OXFORDSHIRE COUNTY COUNCIL'S RESPONSE TO CONSULTATION ON THE FOLLOWING DEVELOPMENT PROPOSAL

Application no: 23/02471/F

Proposal: Erection of 14 two storey dwellings and upgrading of existing access onto the Heyford Road, together with garaging and parking, footpath link, the removal and re-instatement of a section of existing wall and its repair along the Heyford Road frontage, and landscaping and all enabling development

Location: OS Parcel 0622 South Of Jersey Cottages And East Of Heyford Road, Kirtlington

Title : **Site Access Visibility Splays**

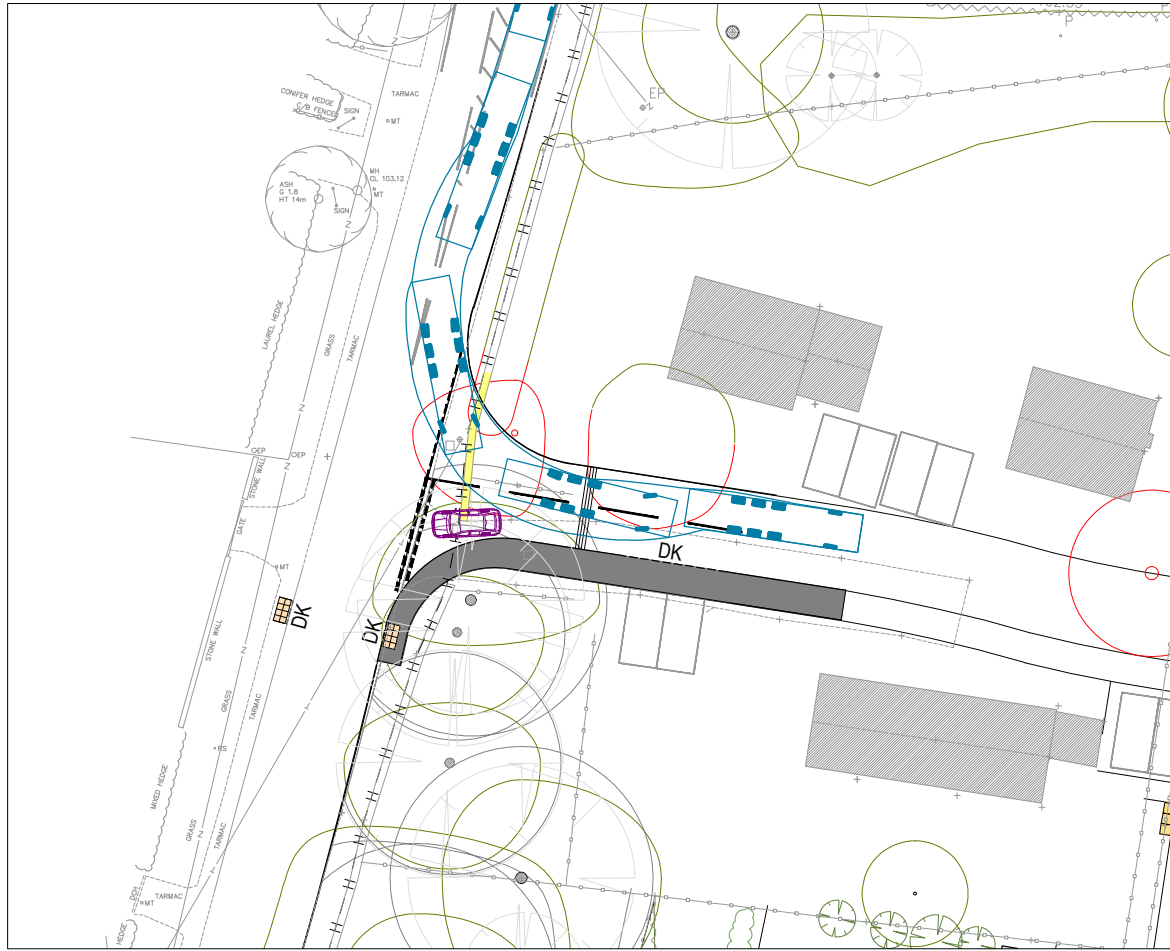
- The visibility to the north from the site access junction is inadequate.
- A Stage 1 Road Safety Audit has not been submitted.
- The swept path of the Refuse Collection Vehicle overhangs private driveways and a hedge

It is difficult to measure the exact northward visibility splay on site due to the presence of the existing wall at the access, which is due to be partly demolished and rebuilt. (The text in the TS, 4.16 and 6.3, says 10m of wall, but drawing no. 8210698/6101 Rev. F says 12m). My observations agree with the visibility splay indicated on this drawing. This shows that 43m can only be achieved if the far end of the splay is offset by 0.8m from the kerb. However, there is no justification for this – the splay must be measured to the kerblines as defined in Fig. 7.18 of Manual for Streets:

The Y distance is approximately 35m when measured to the kerblines.

There are concerns specific to this site that oppose a relaxation of the standards:

1. The presence of the speed cushions will tend to position cyclists and motorcyclists adjacent to the kerb and away from the centre of the lane where they would be more visible. Section 10.5.3 of Manual for Street 2 says “*Therefore, a more accurate assessment of visibility splay is made by measuring to the nearside edge of the vehicle track.*” The splitter island and cushions will ensure that the nearside edge of all vehicle tracks are very close to the kerb.

2. The ATC was positioned just north of Akeman Close, about halfway along the splay. Southbound vehicles may well be travelling faster than the recorded values when they first come into view and decelerate as they reach the built-up area.

3. A restricted view must be avoided so that exiting vehicles do not tend to project out beyond the give way line. This is a busy “A” road and as a bus route, the recommended minimum carriageway width is 6.5m. The proposed kerb realignment will locally reduce the carriageway slightly below this distance (para. 4.8 of the TS says 6.3m while drg. no. 6101 says 6.4m), so a further narrowing due to a projecting vehicle may cause an unsafe obstruction.

Title :
**Swept Path Analysis
11.6m Refuse Vehicle**

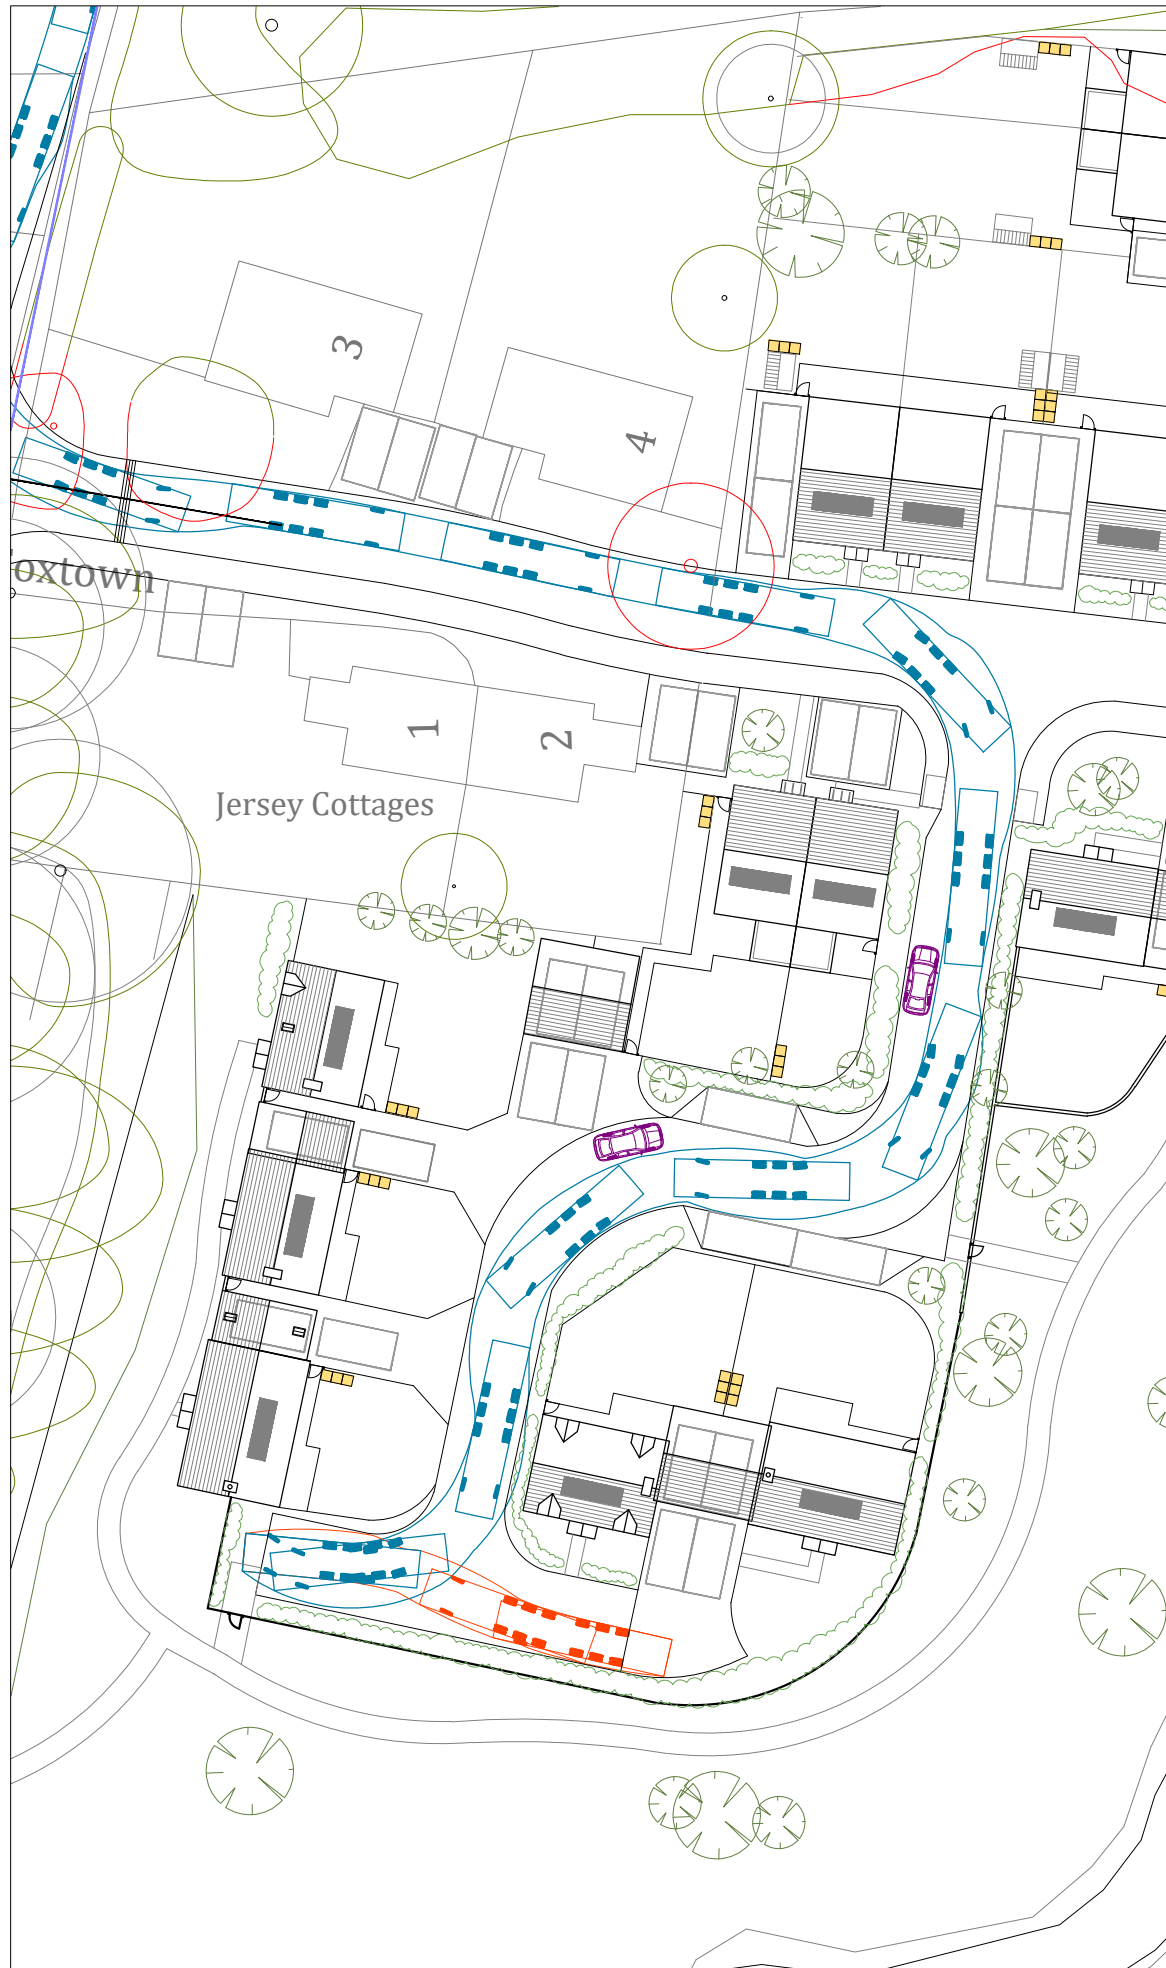
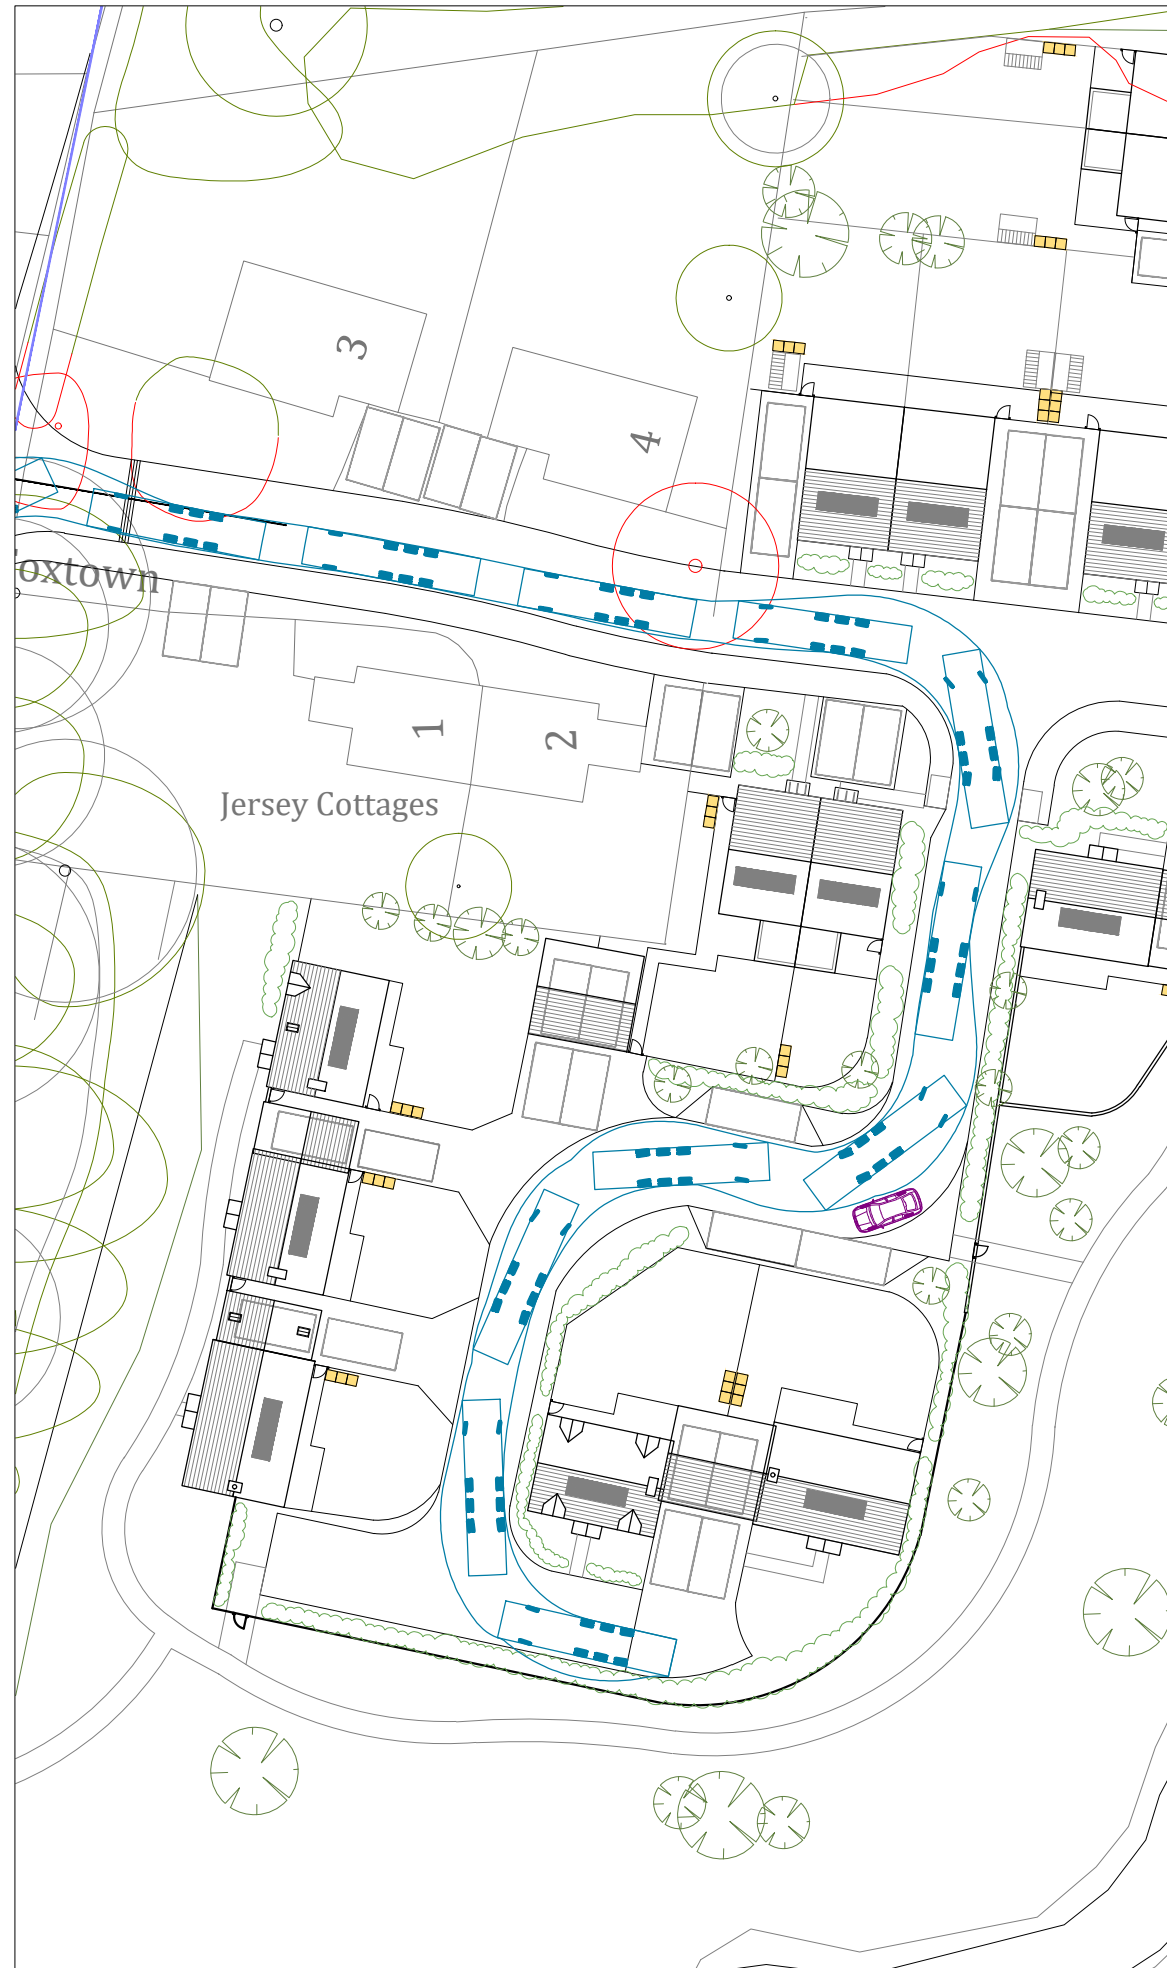
The swept path analysis of the Refuse Collection Vehicle (RCV) indicates it colliding with a hedge beyond the carriageway and overhanging/overrunning private drives, neither of which is acceptable.
